Prestons Industrial Estate

○ State Significant
Development
Modification Assessment
(SSD 7155 MOD 6)

December 2018

SITE PLAN
1: 1200 scale

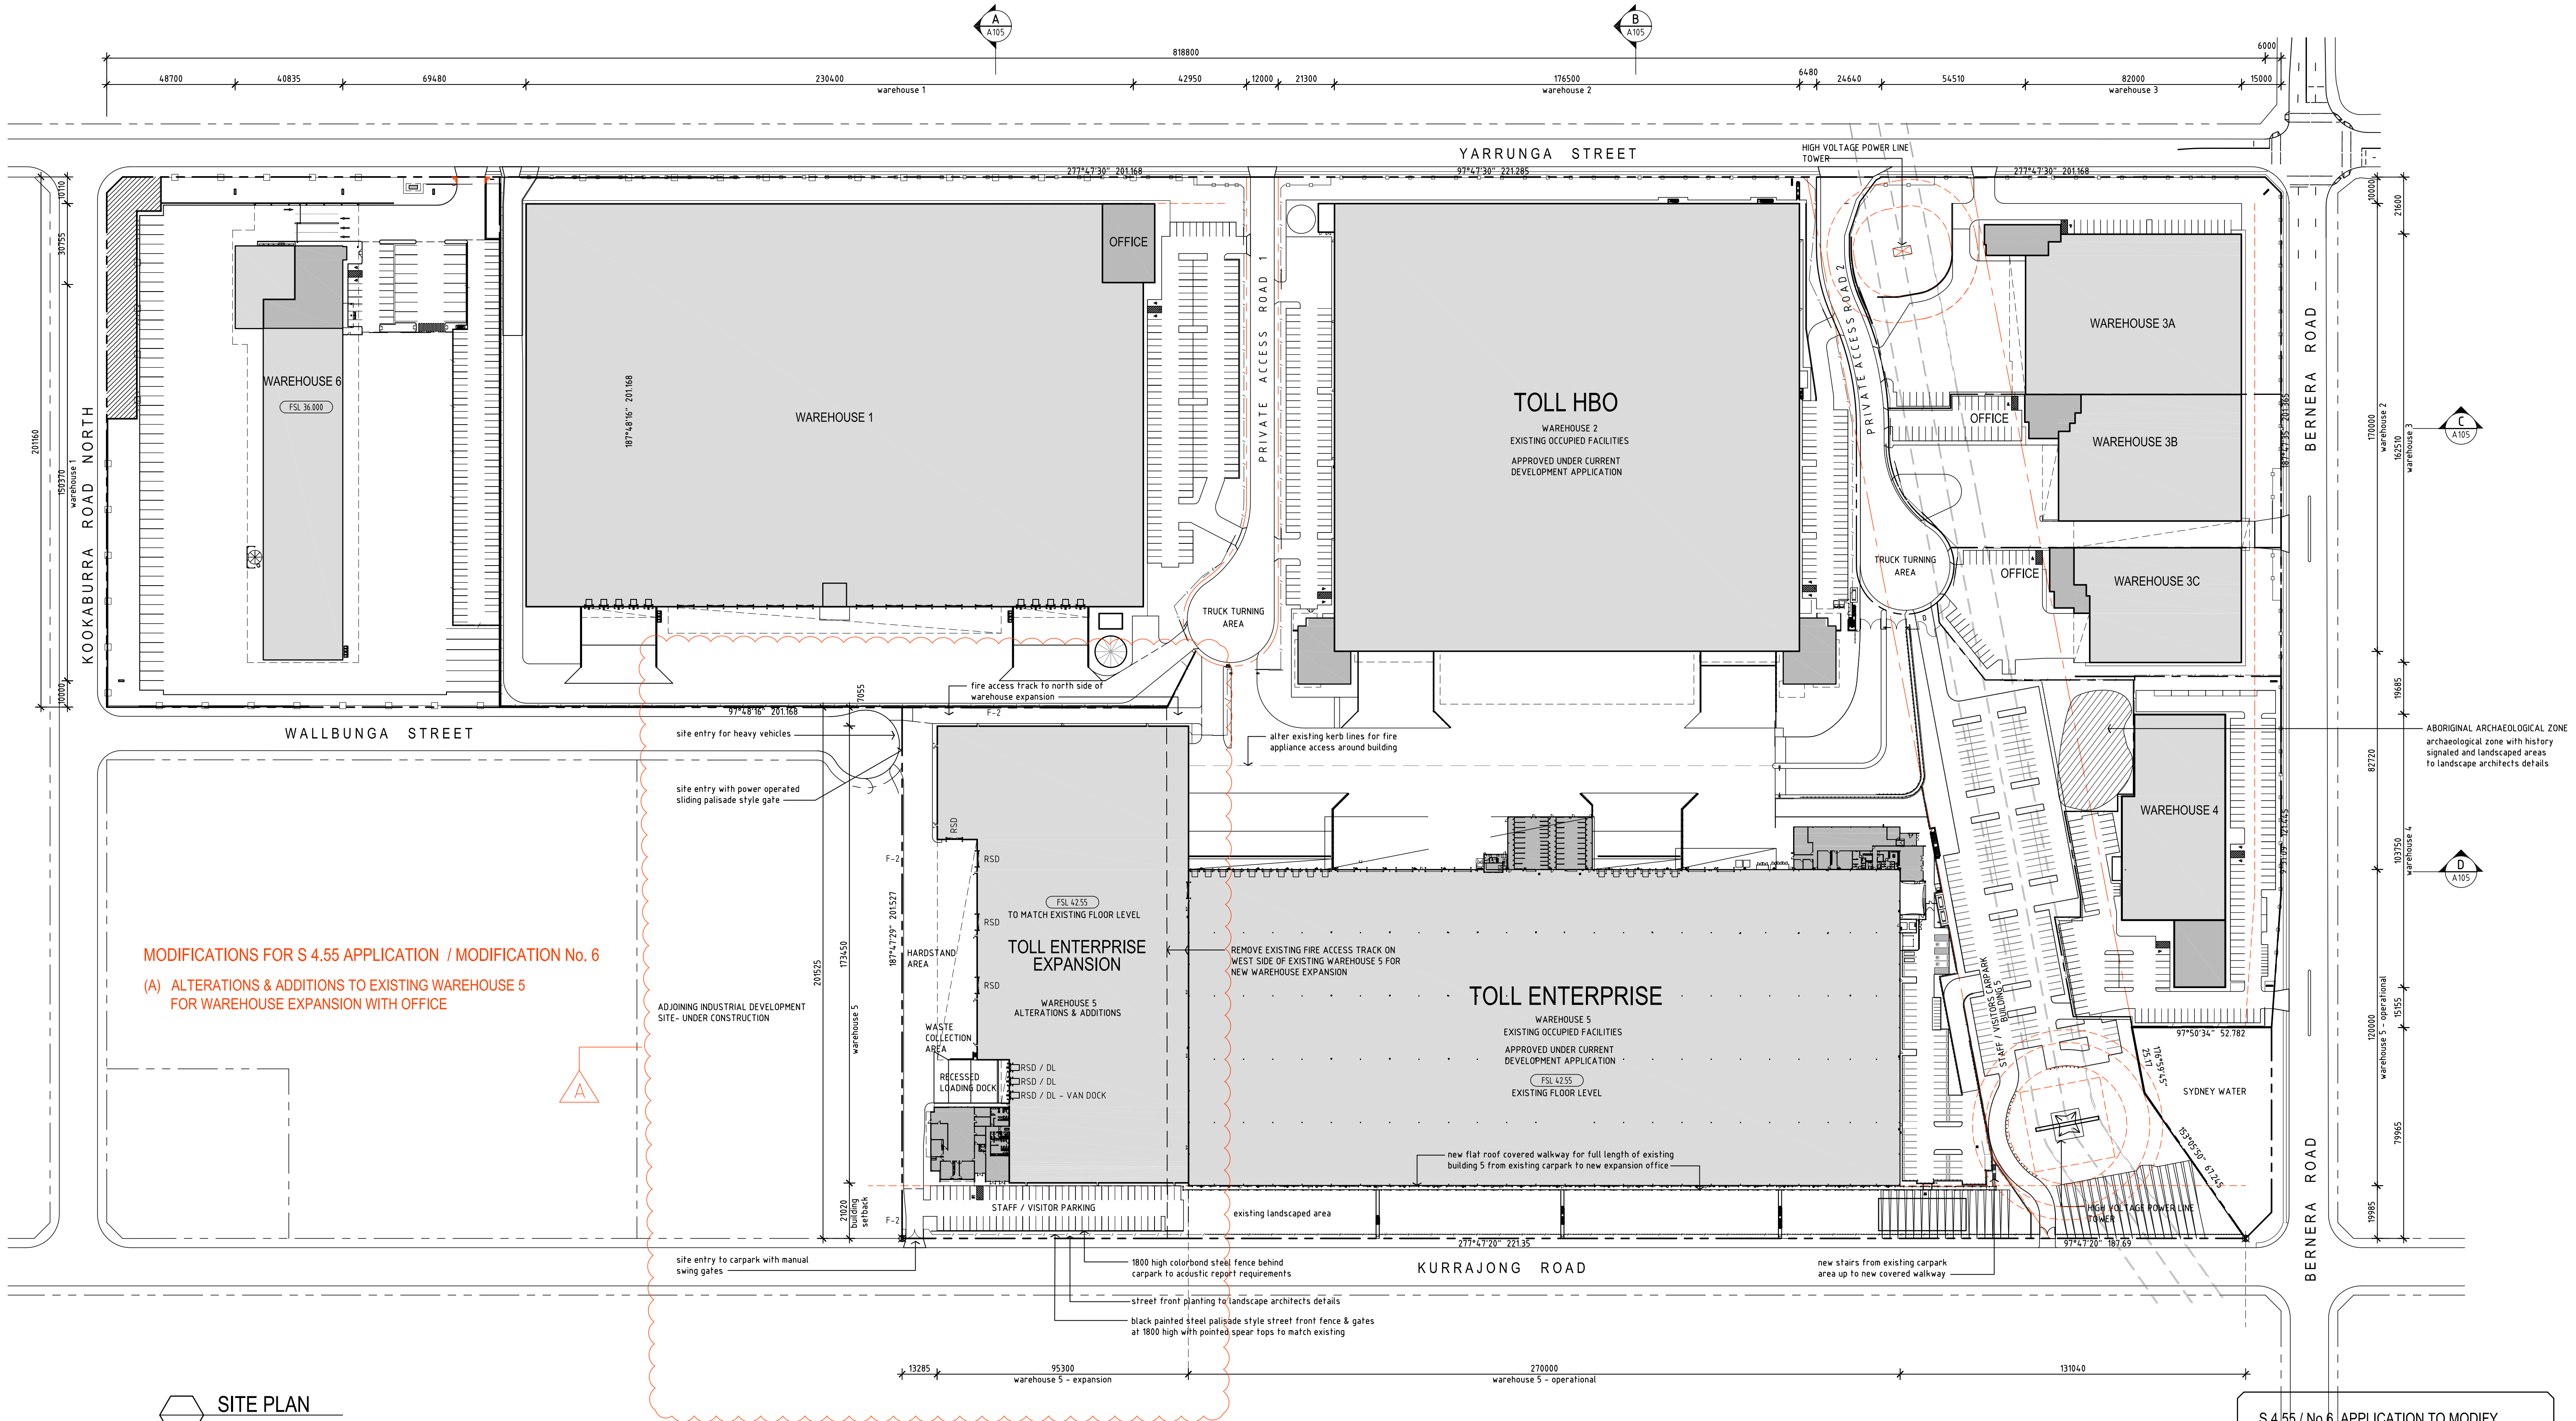
- the Kurrajong Road egress be redesigned to allow for left turns only by light vehicles and to meet the design requirements of Council's Development Control Plan (DCP) 2008 in relation to the proposed access which requires that light vehicles enter the site via a right of way through the adjoining property to the west

- an Operational Traffic Management Plan (OTMP) and signage plan are prepared to prohibit the use of Kurrajong Road by heavy vehicles
